Submission No.			190	
Organisation Name or Name of Submitter			Michael A Doyle and Carmel Smith Doyle	
Item No.	Section Ref.	Page No.	Observation Statement	TII Response
Re: Metrolink Railway Order 2022, Estuary to Charlemont, Reference Number NA29N.314724				
1	Letter	1	<p>I live at 34 Dartmouth Road.....</p> <p>Firstly, in general, I am in favour of the broad aim of the Metrolink project to connect Dublin’s city centre to our national airport.</p> <p>However, as a resident living in the Dartmouth/Charlemont area, I wish to set out a number of observations, for the Board’s consideration, regarding the proposal to locate the Terminus station at Charlemont-Dartmouth.</p> <p>My family home is in the midst of the community where the Terminus station at Charlemont is proposed to be located, and is dangerously close to the proposed very deep pile insertions and deep station box excavations.</p> <p>I would request that An Bord Pleanála give very serious considerations to the important issues raised in this submission, and, in consequence, mandate Planning Conditions appropriate to the nuisance value inherent in this application for a major transport hub located in a heretofore quiet Victo

SEE CROSS SECTION IN
DRAWING ML-ST 307 O-A8

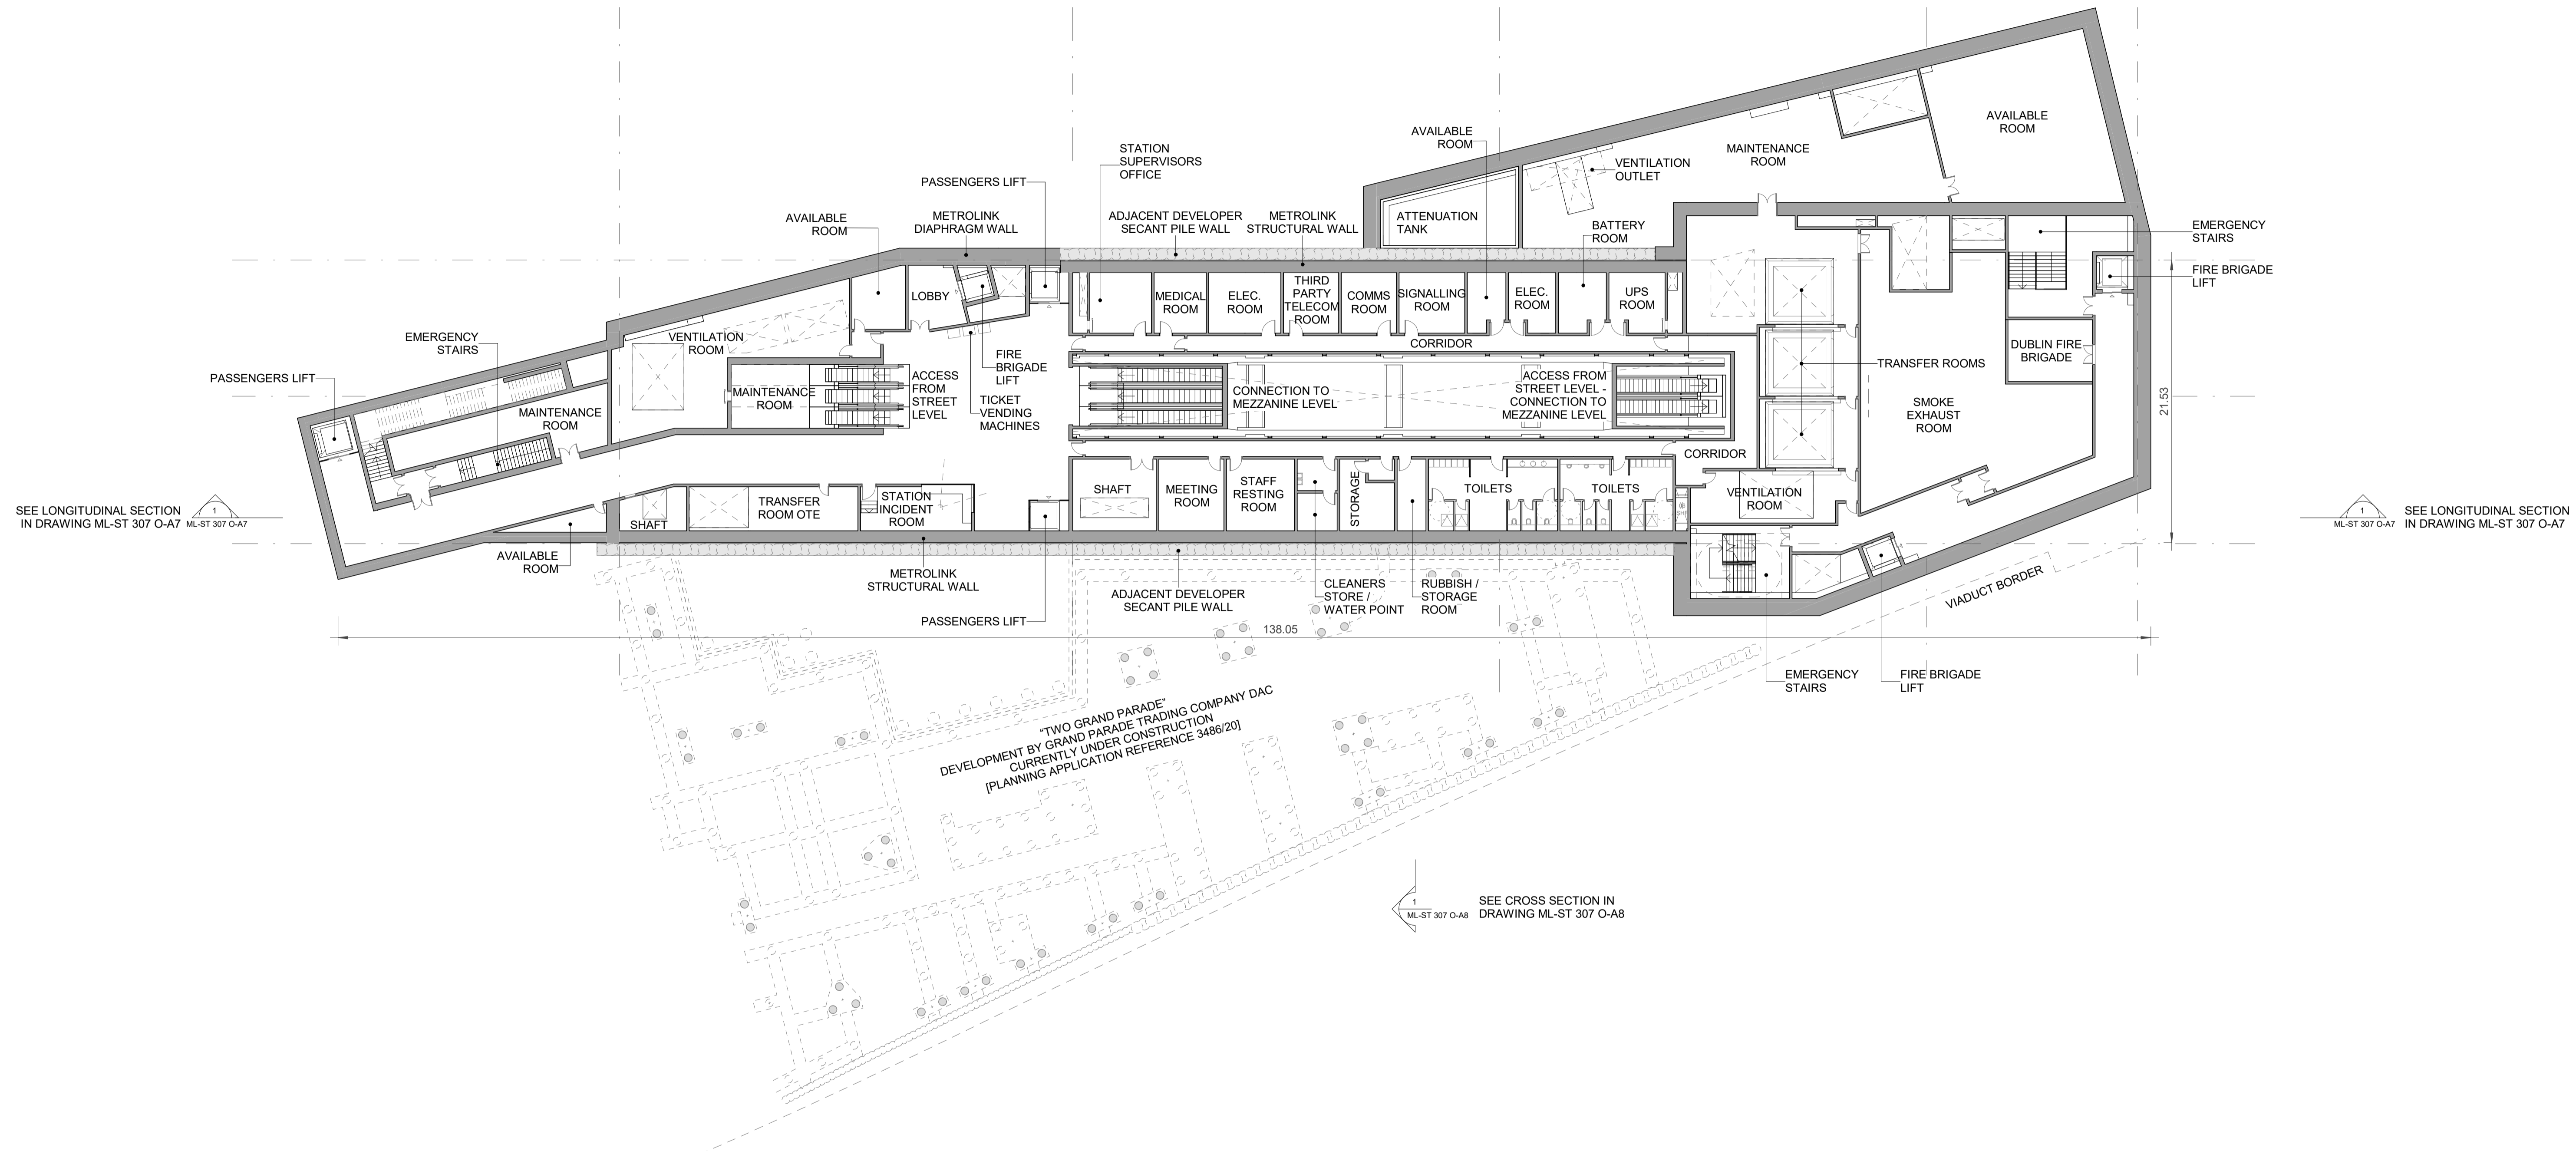
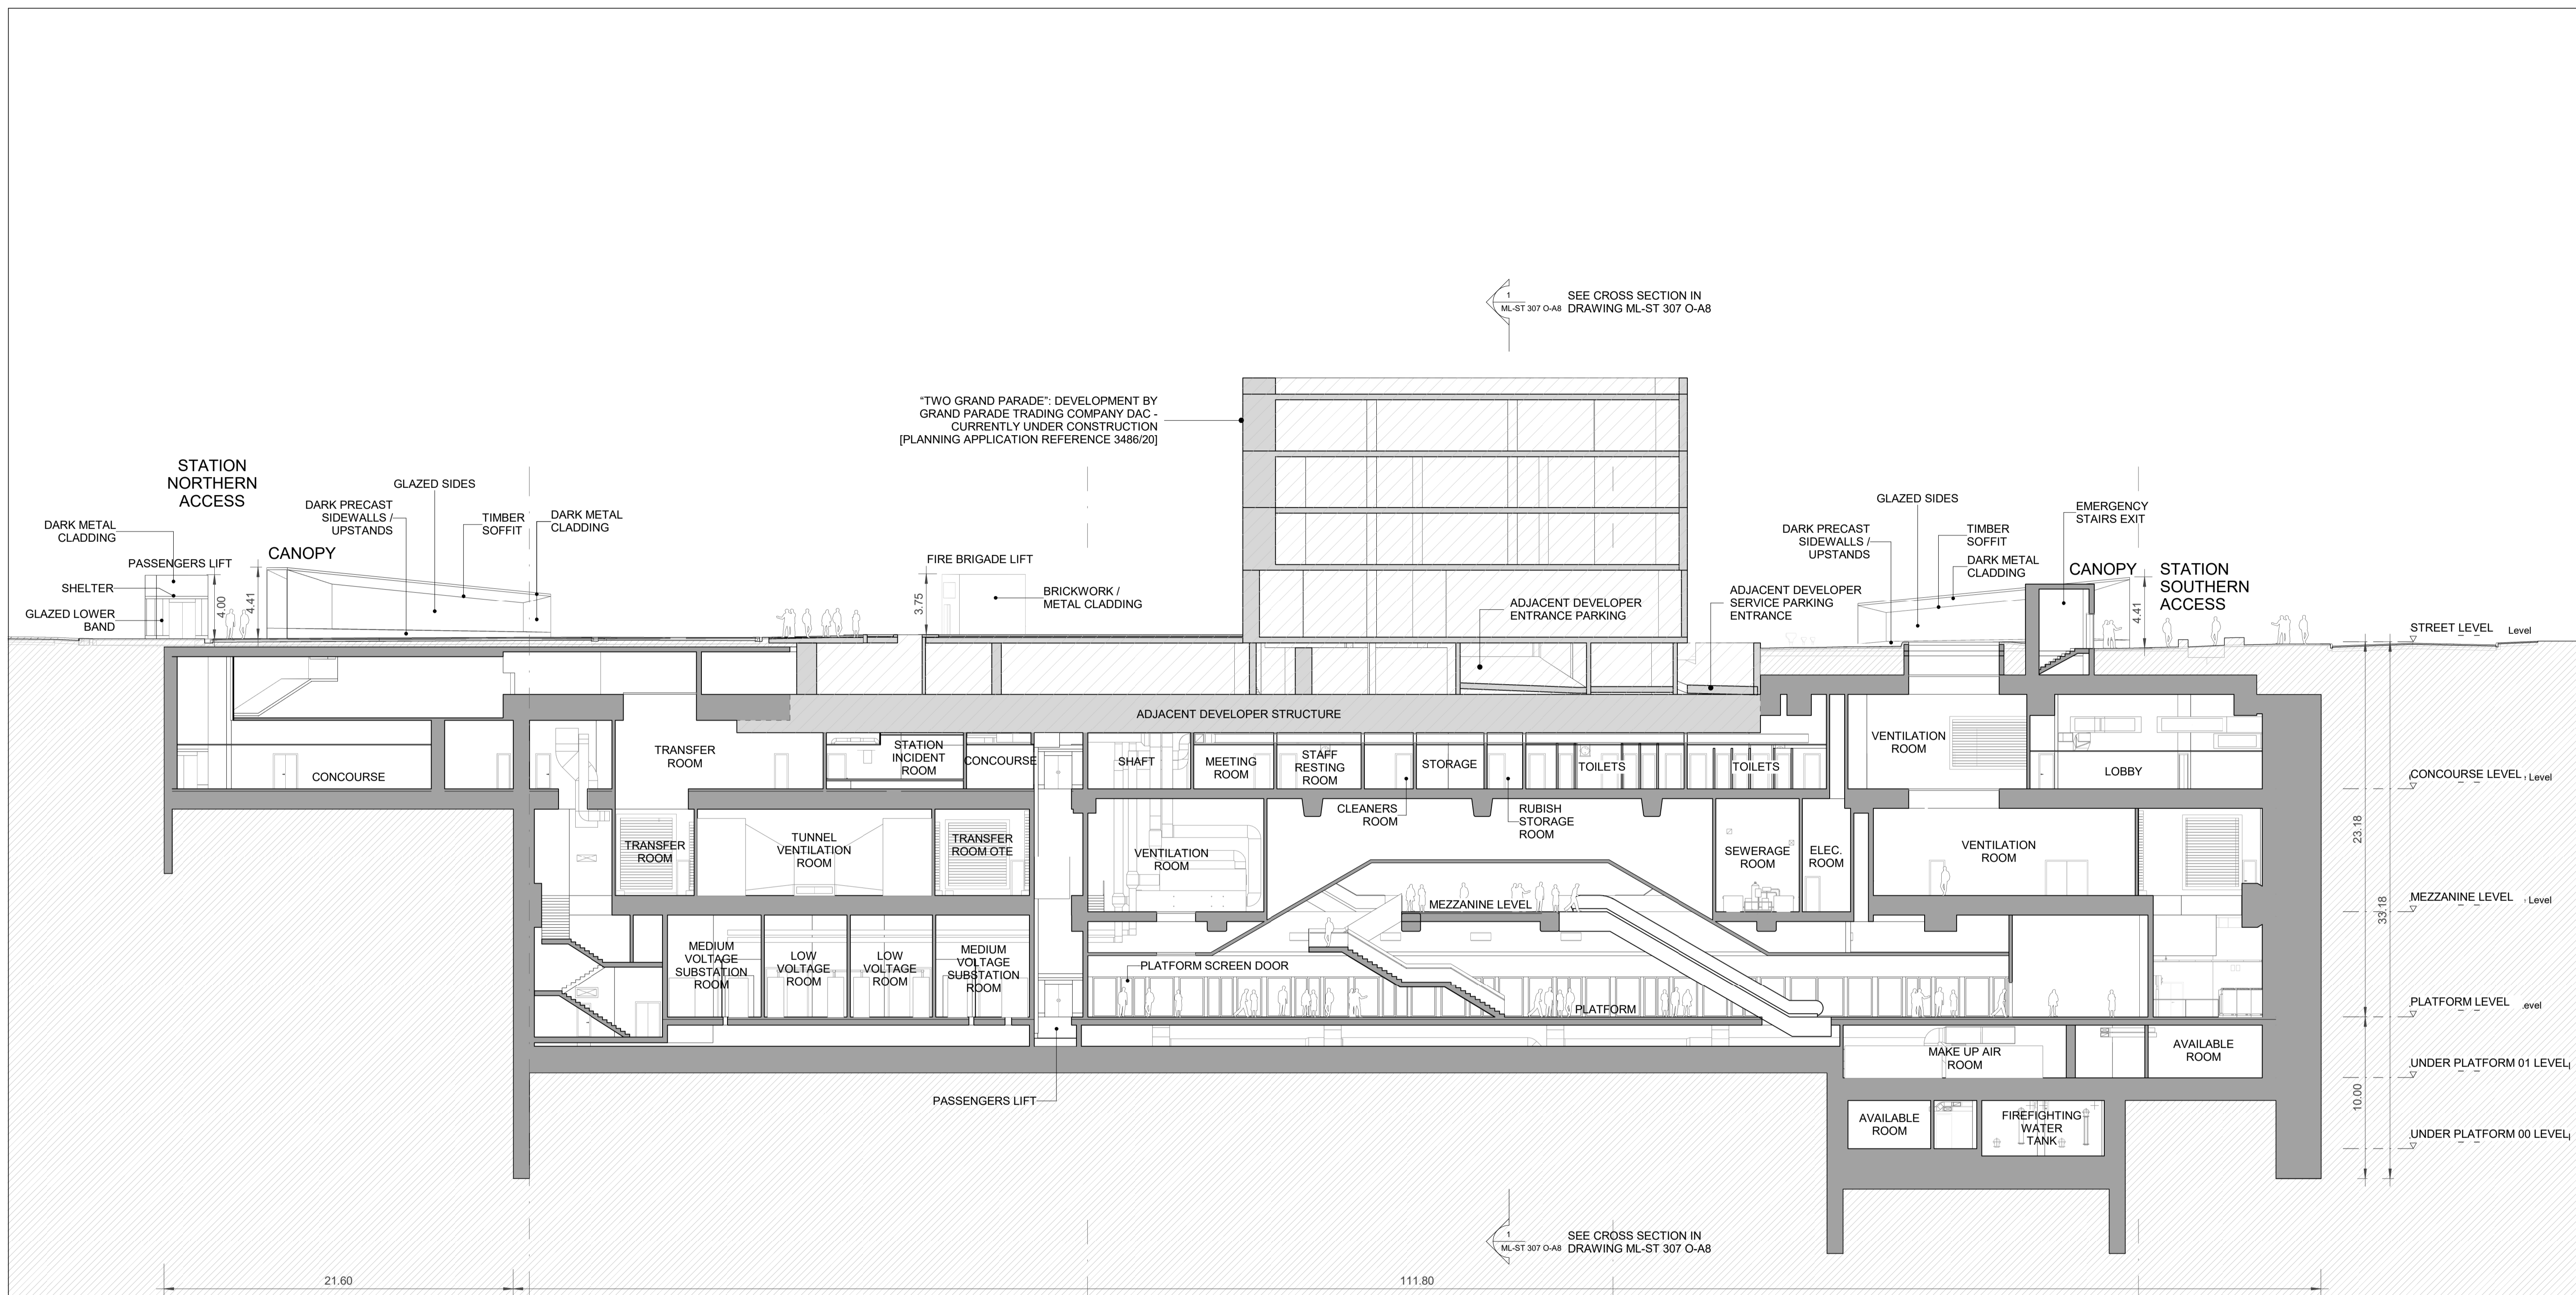
6	SETTLEMENT, SUMMARY	6	<p>1.1 ACCURACY OF DEPICTION OF BORED PILES ON DARTMOUTH ROAD, Drawings do not accurately reflect actual position of bored piles.</p>	<p>The drawings do depicted the location of the station structure in relation to Dartmouth Road. Please refer to the submitted Railway Order drawings, Structures Details, Book 2 of 3, drawing ML1-JAI-SRD-ROUT_XX-DR-Z-02090, which indicates the outline of the station external walls (Diaphragm Wall piles) in relation to the properties along Dartmouth Road.. The EIAR Chapter 5, MetroLink Construction Phase, Section 5.10.13 and Appendix A5.3 Section 8.14, also indicates the position of the station wall and explains the proposed construction of Charlemont Station.</p> <p>Further information of the depth of the proposed station structure is provided on station floor level structural plan drawings ML1-JAI-SRD-ROUT_XX-DR-Z-02092 to 02095 together with associated longitudinal section Drawings ML1-JAI-SRD-ROUT_XX-DR-Z-02096.</p>
